WAYNFLETE LOWER SCHOOL - ADDENDUM #2

date: Monday, February 06, 2017
project: Waynflete Lower School Addition & Renovations, 2013-0050
prepared by: Austin Smith Scott Simons Architects
to: Cordelia Pitman Wright Ryan Construction
Rick Bergeron Wright Ryan Construction
Luke Dione Wright Ryan Construction
Anne Hagstrom Waynflete School
Patrick Boure Waynflete School
Phil LaClaire PML Project Management

Subject: Addendum #2 to Bid Documents of January 12, 2017

**A511R**

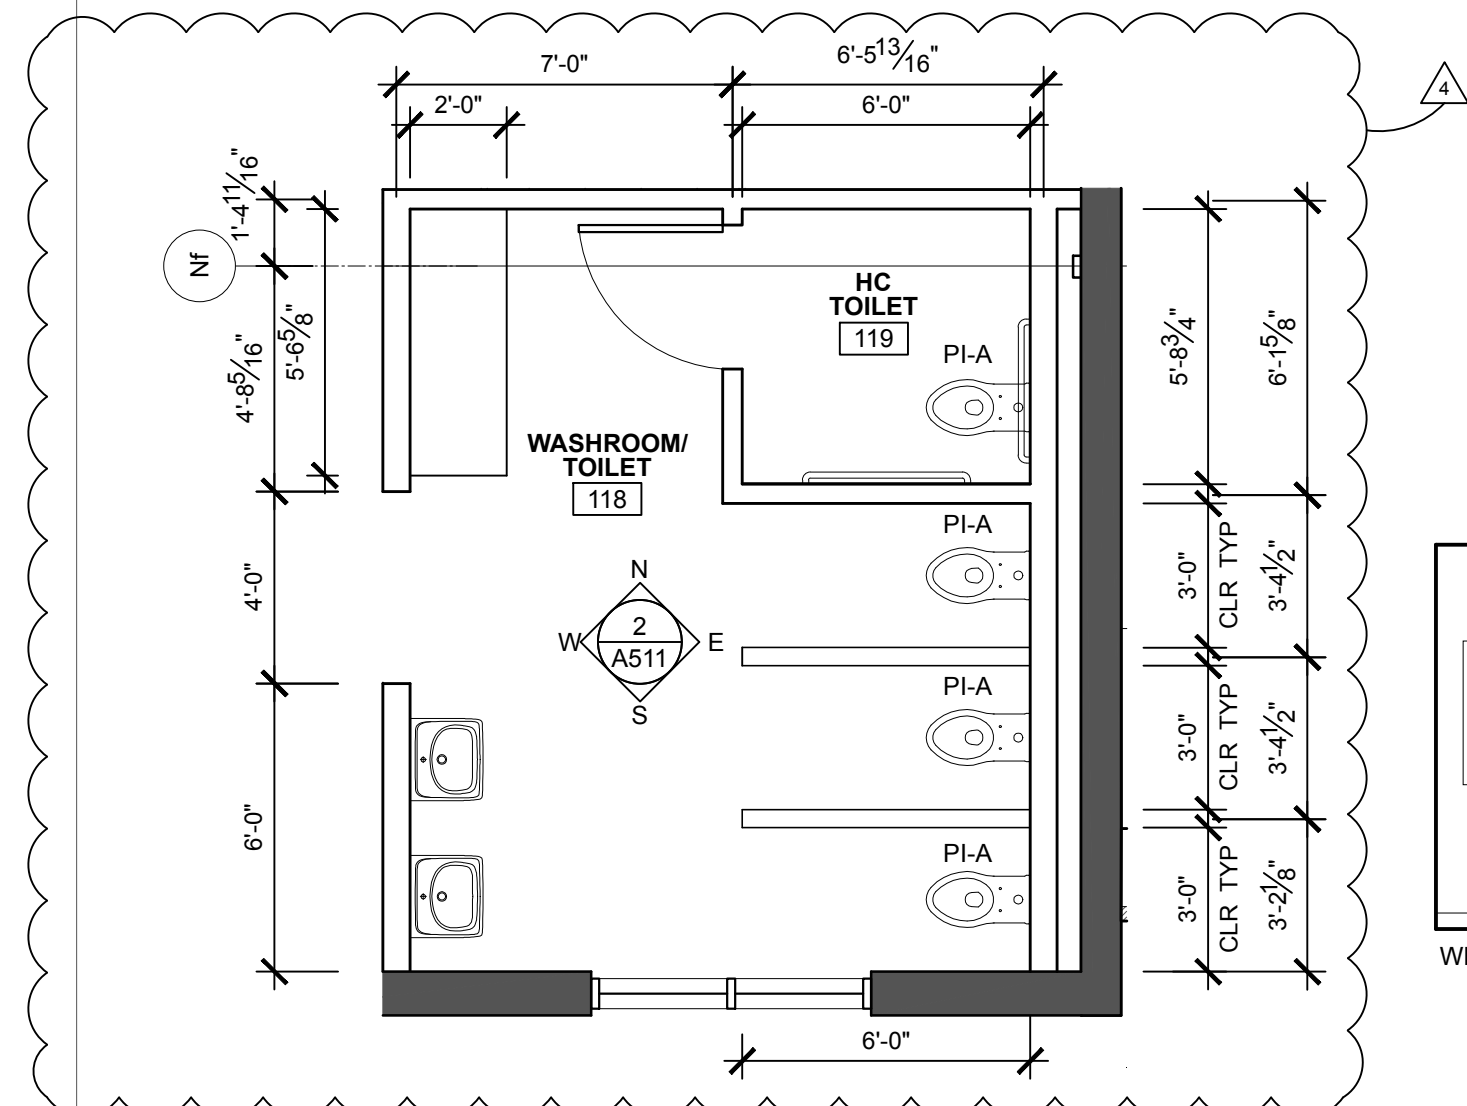
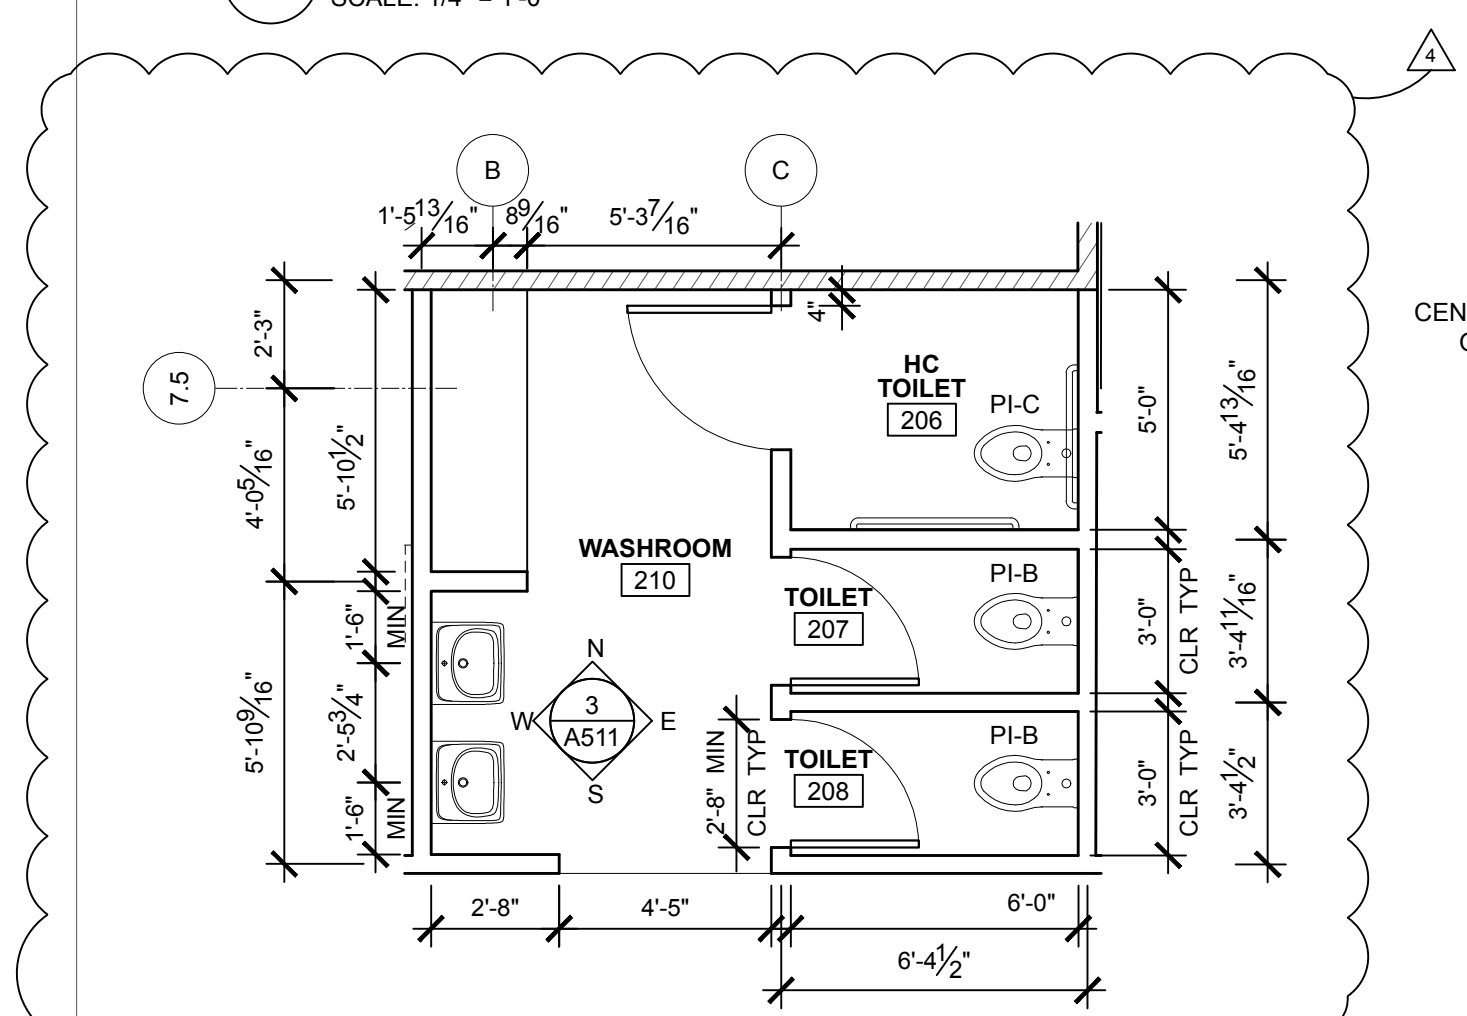
A. Hohmann & Barnard report that they now have the 2-Seal Tie (wing nut) for a 6" insulation system. See attached catalog sheet.
- 2-Q34 Question 34 Q. Are we only doing the bathrooms on A-511? or are we also doing 016,122,213,1214,19?

A. All bathrooms, toilets, or washrooms as indicated in plans A101, 102, 103, A141, A142 and A143, and on finish schedule shall be provided beyond typical examples and notes shown on A511.
